CITY OF ALBUQUERQUE
 PLANNING DEPARTMENT
 DEVELOPMENT REVIEW BOARD

Project# 1009375

12DRB-70252 MAJOR – SITE DEVELOPMENT PLAN FOR BUILDING PERMIT

**HYDROLOGY DEVELOPMENT SECTION
DEVELOPMENT REVIEW BOARD MEMO**

Sheet Title:
ELEVATIONS
 Date: August 9, 12
 Drawn: S.T.WILDER
 Checked: S.T.WILDER

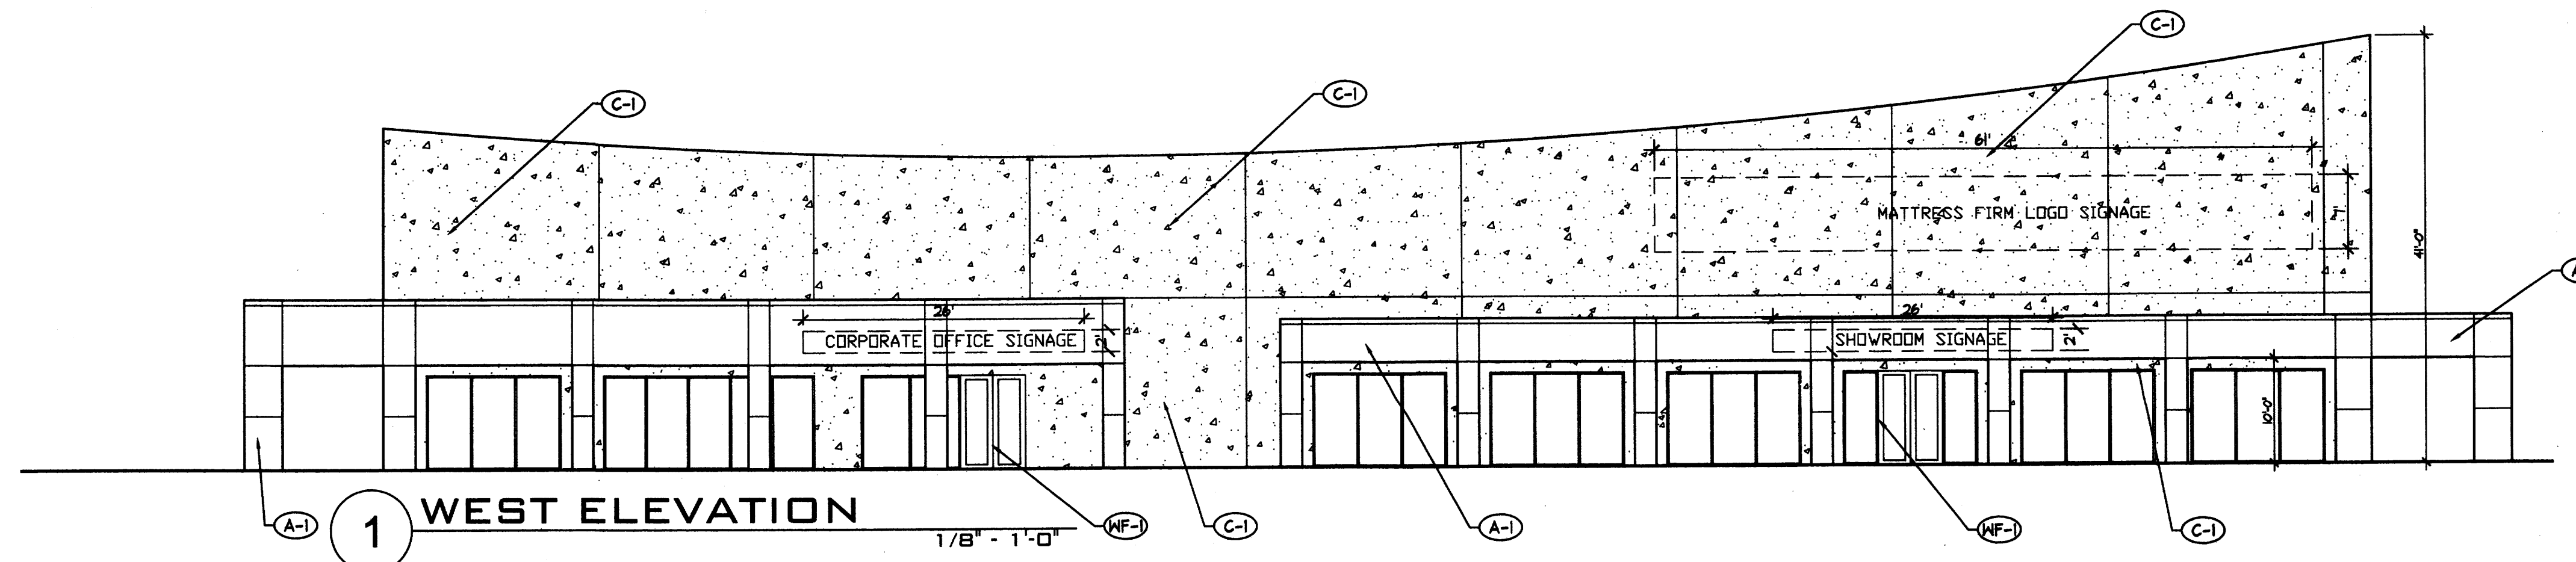
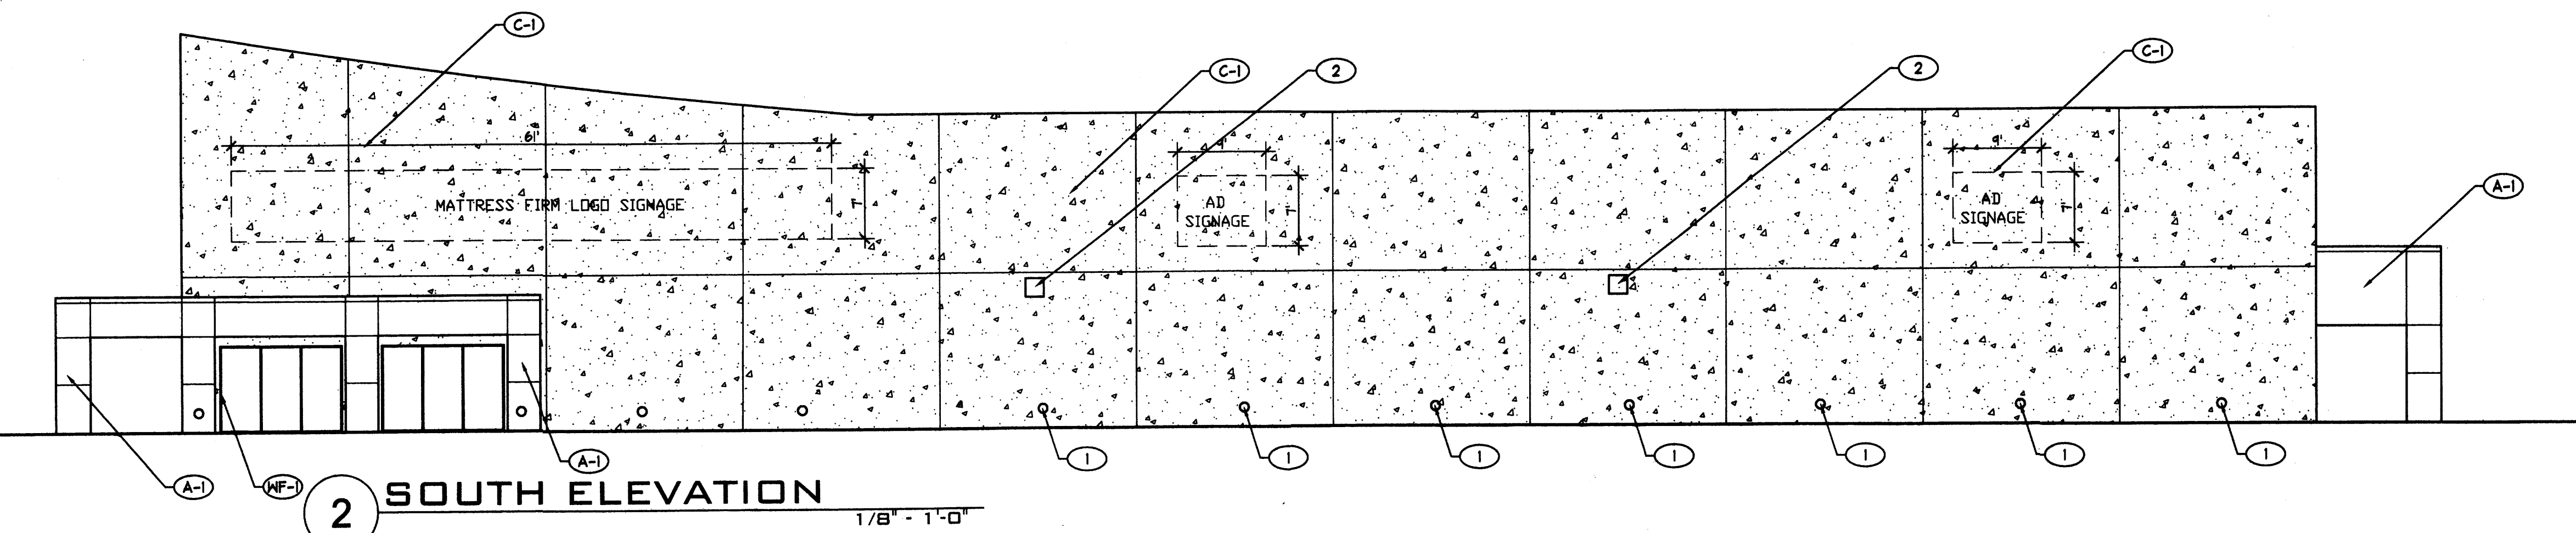
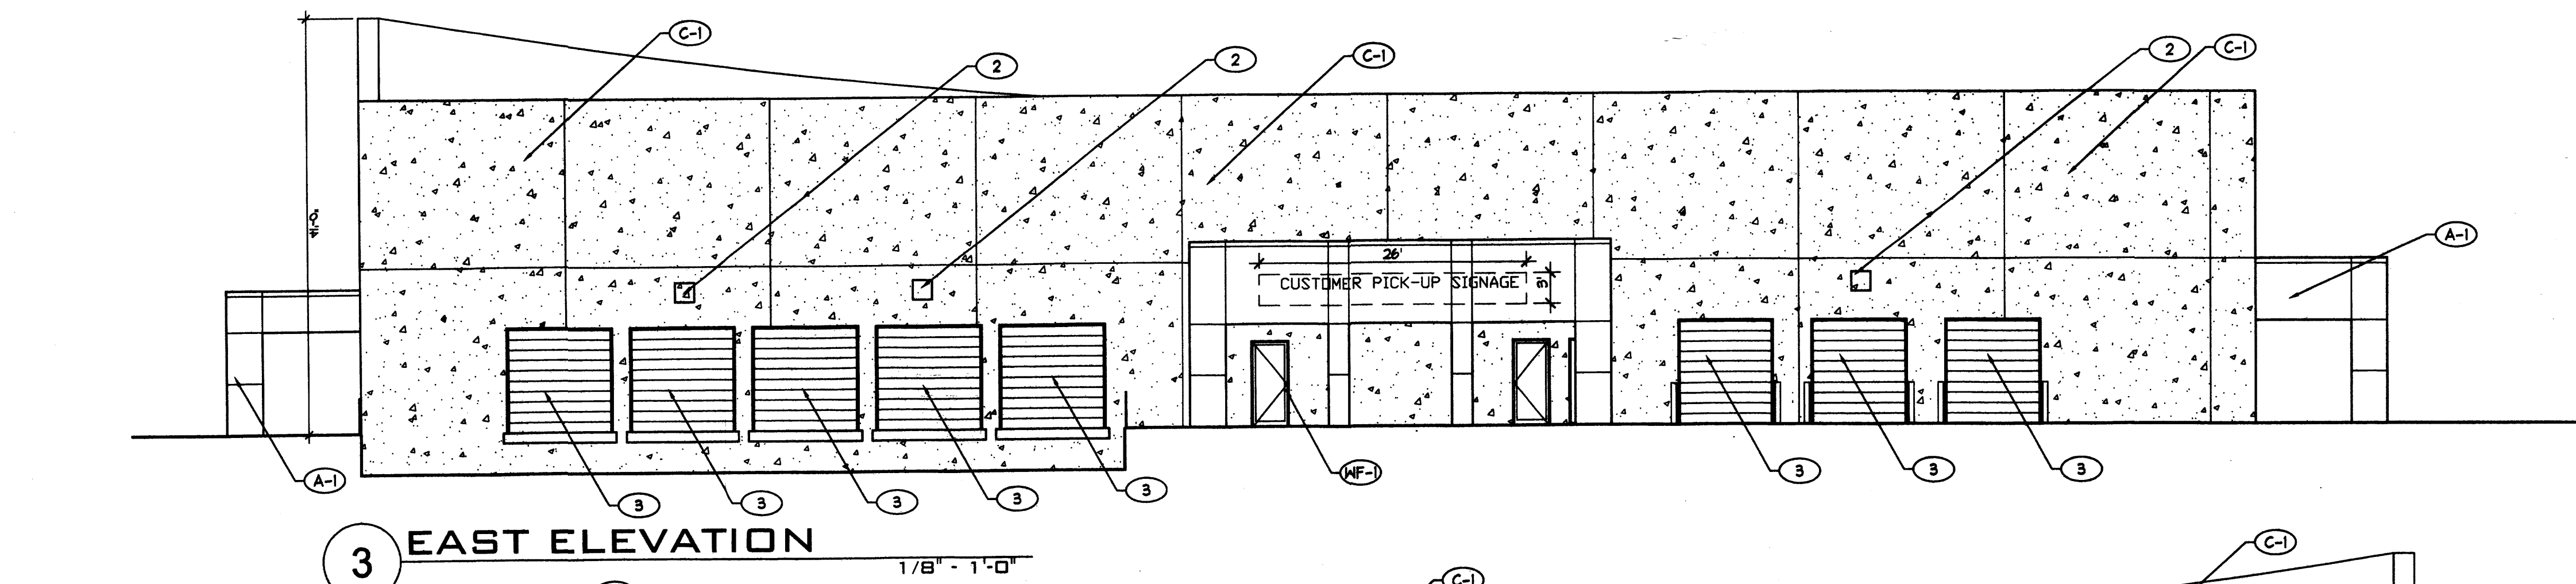
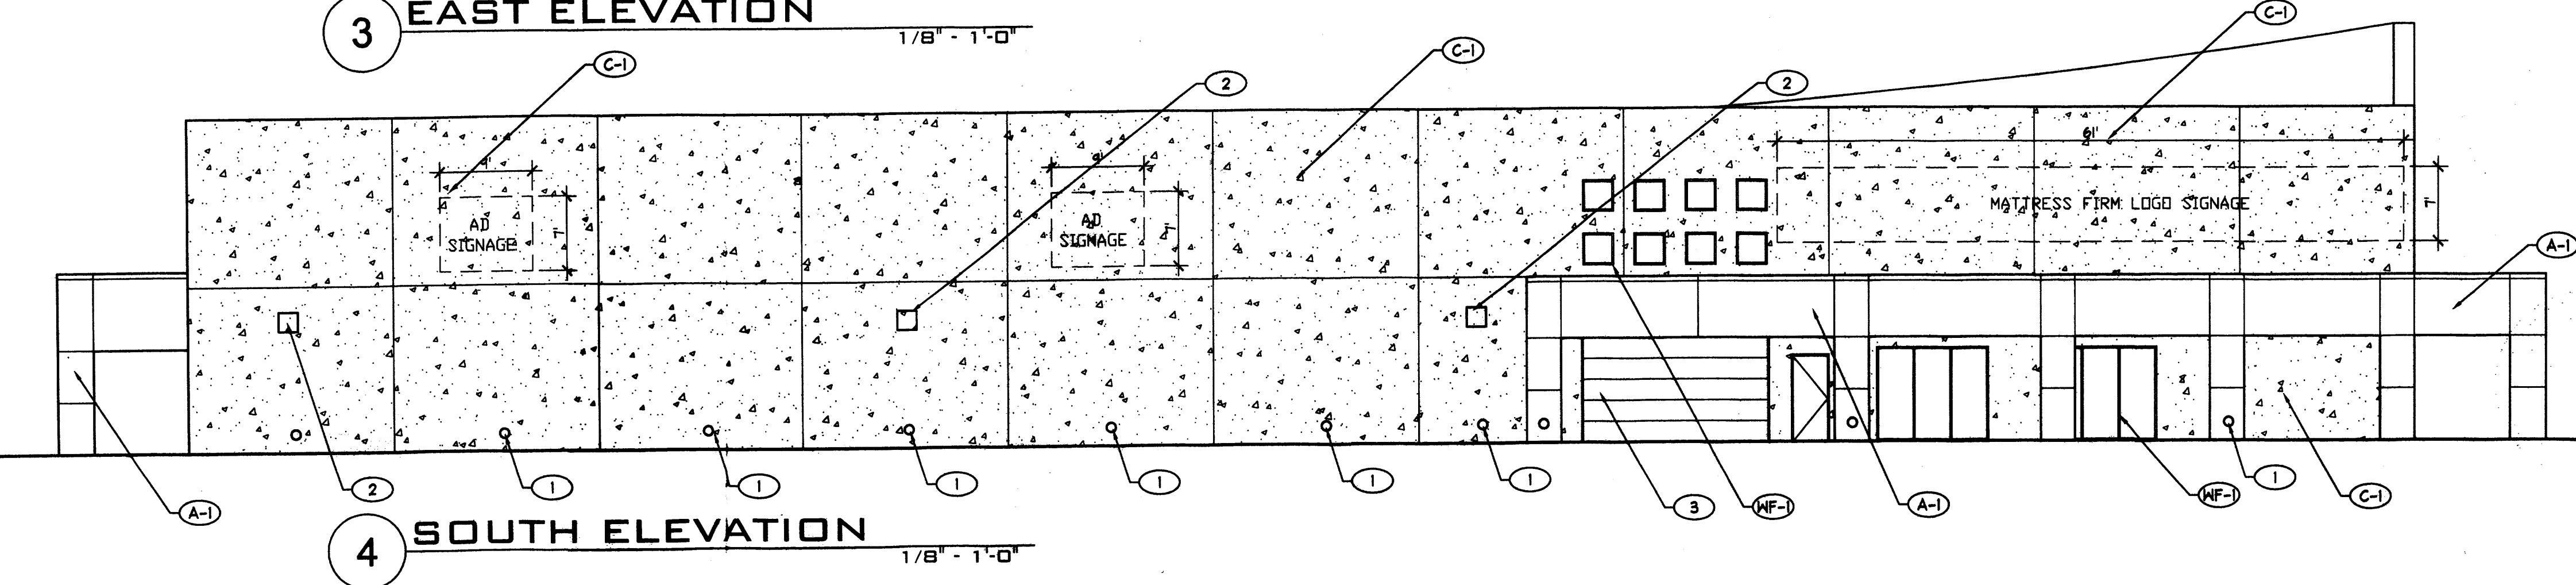
PARKS AND RECREATION
ABCWUA
PLANNING DEPARTMENT Refer to comments from Zoning Enforcement for compliance with Zoning Code. plus any public hearing comments. Colors need to be called out on building elevation sheets. Buildings A and B do not conform to site plan for subdivision Design Requirements. The use of metal wall panels exceeds the "accent" as described in the Design Requirements, and CMU blocks are not included as an acceptable material.
